KITITAS COUNTY

TO: All Staff
FROM: Kelee Hodges, Engineer Tech II on behalf of Justin Turnbull, County Surveyor
DATE: April 5, 2022
SUBJECT: County Survey Review of BL-22-00006 Ritchie

RITCHIE PROPERTY

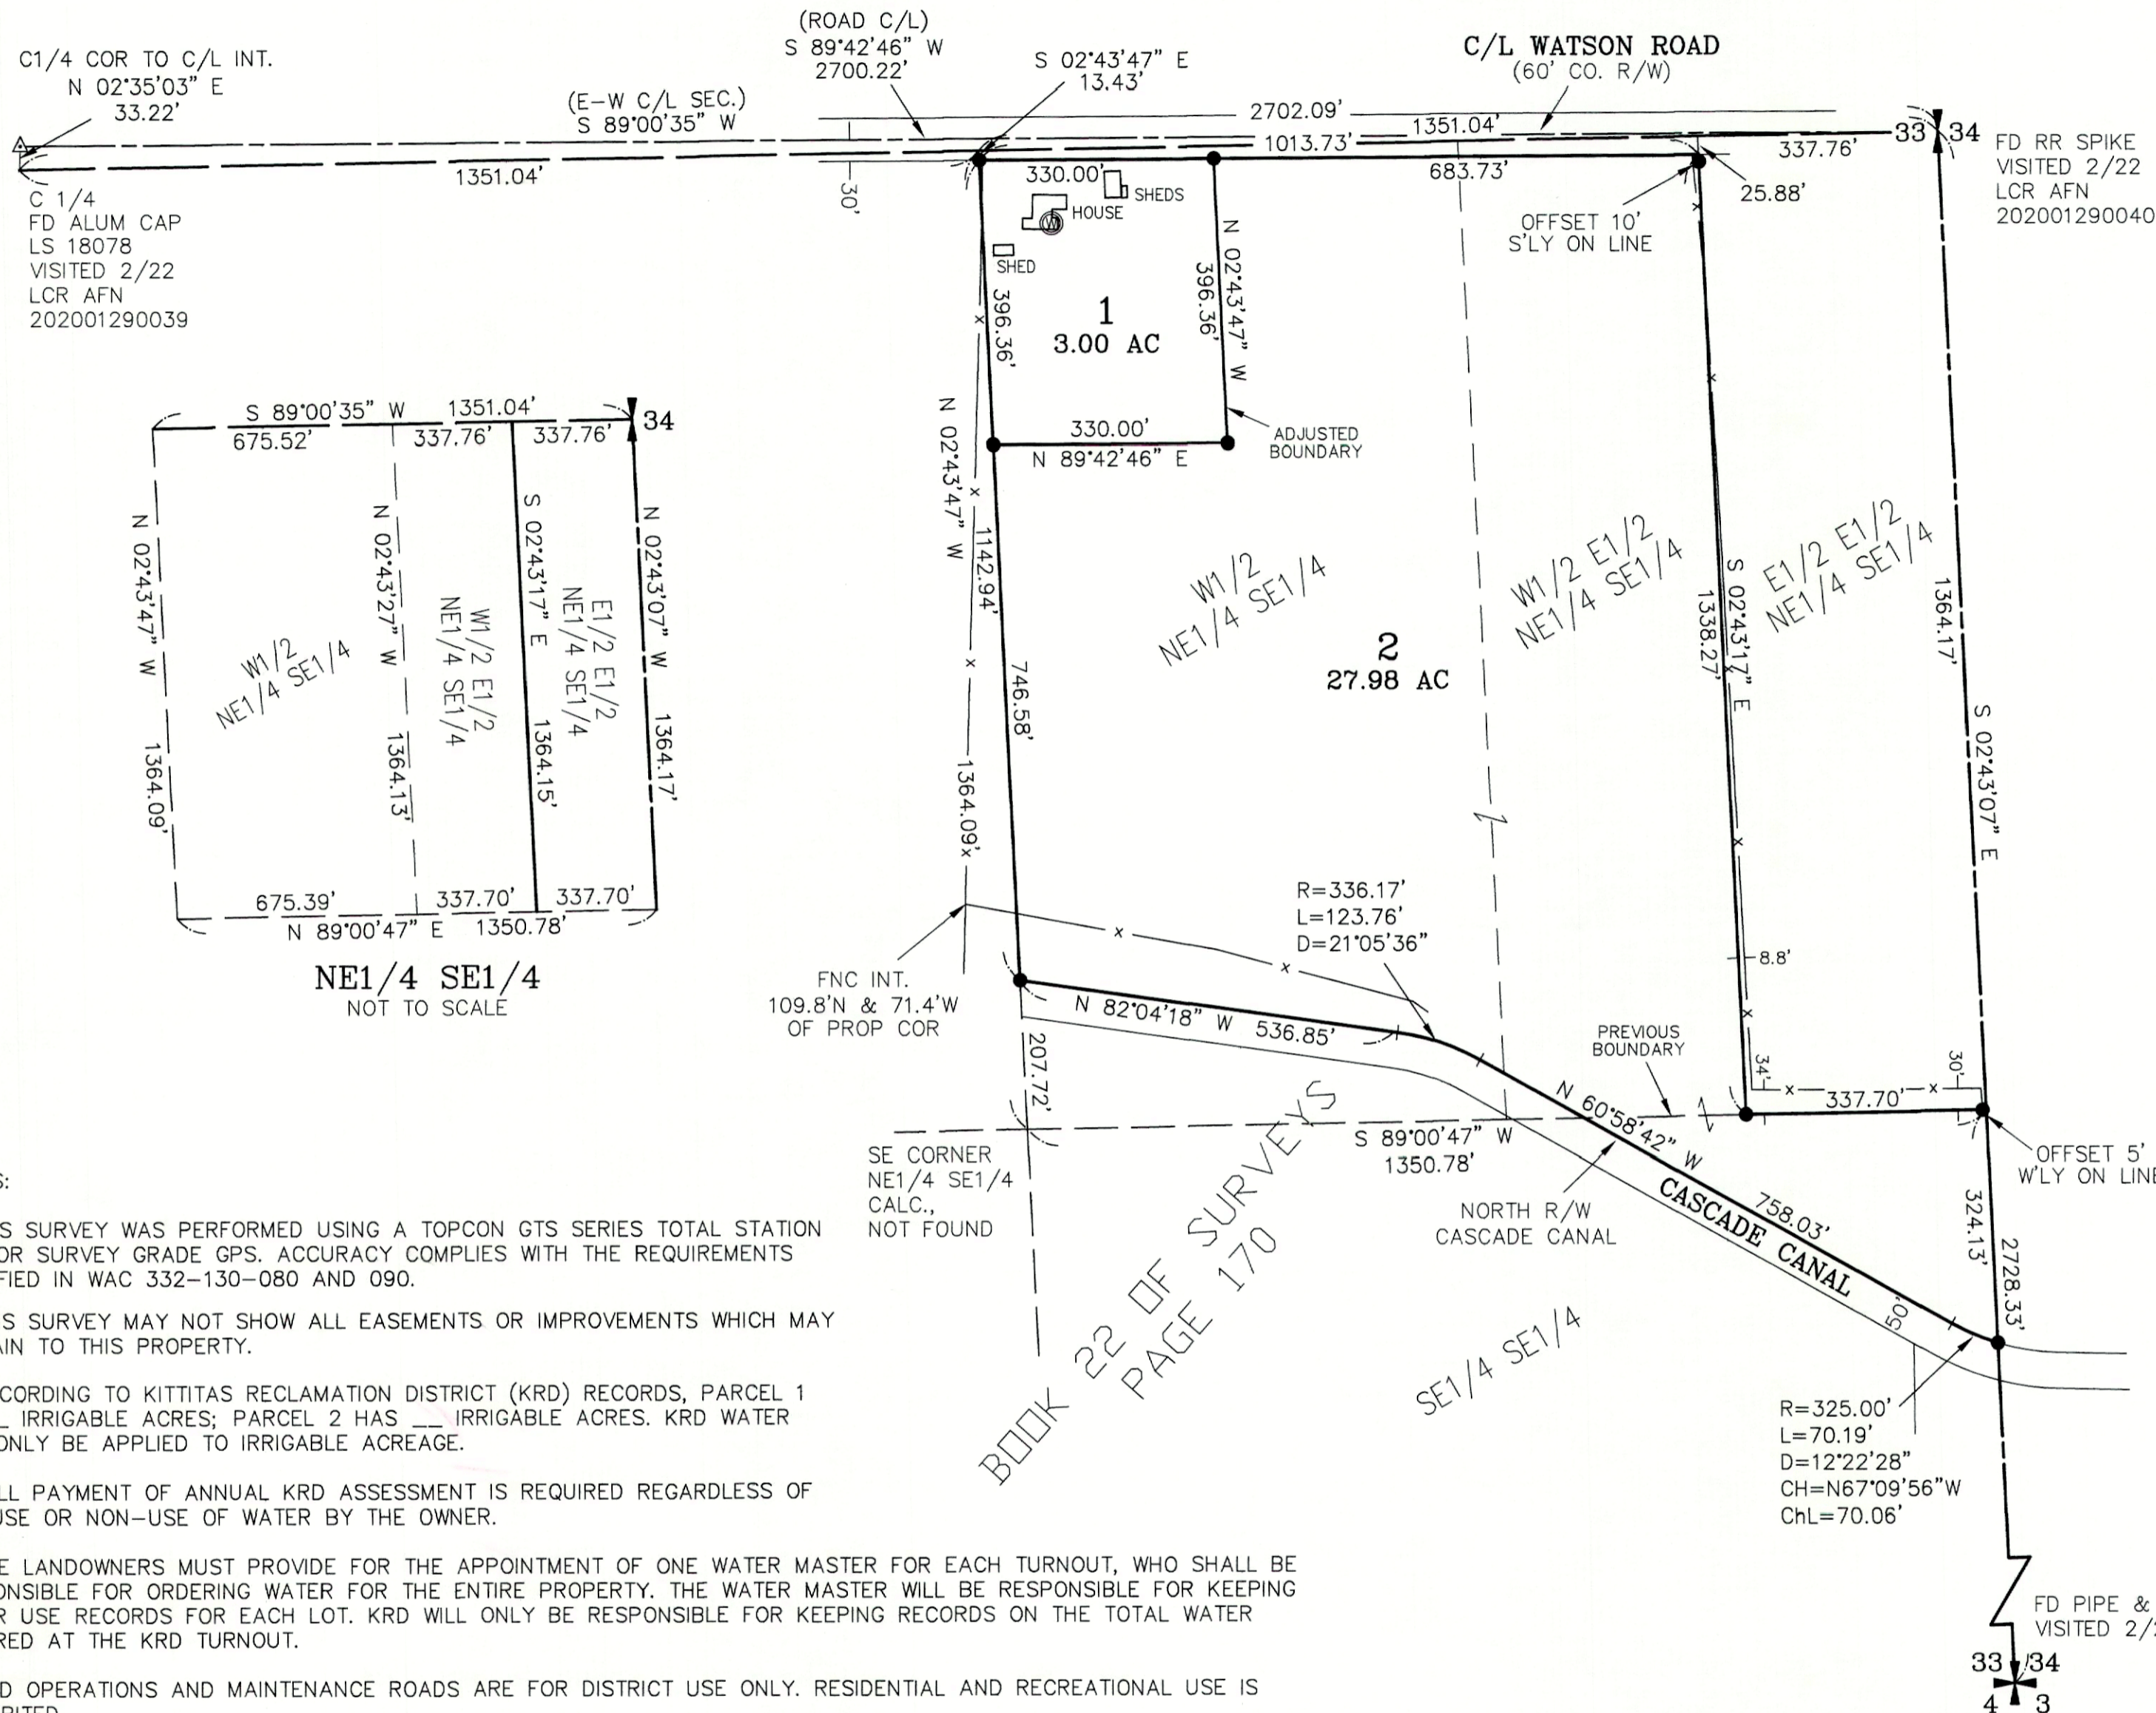
1. Acreage quantity does not match the total of parcel acreage before the BLA.
2. Parcel 1 lot closure sheets does not match the parcel 1 dimension on the BLA.
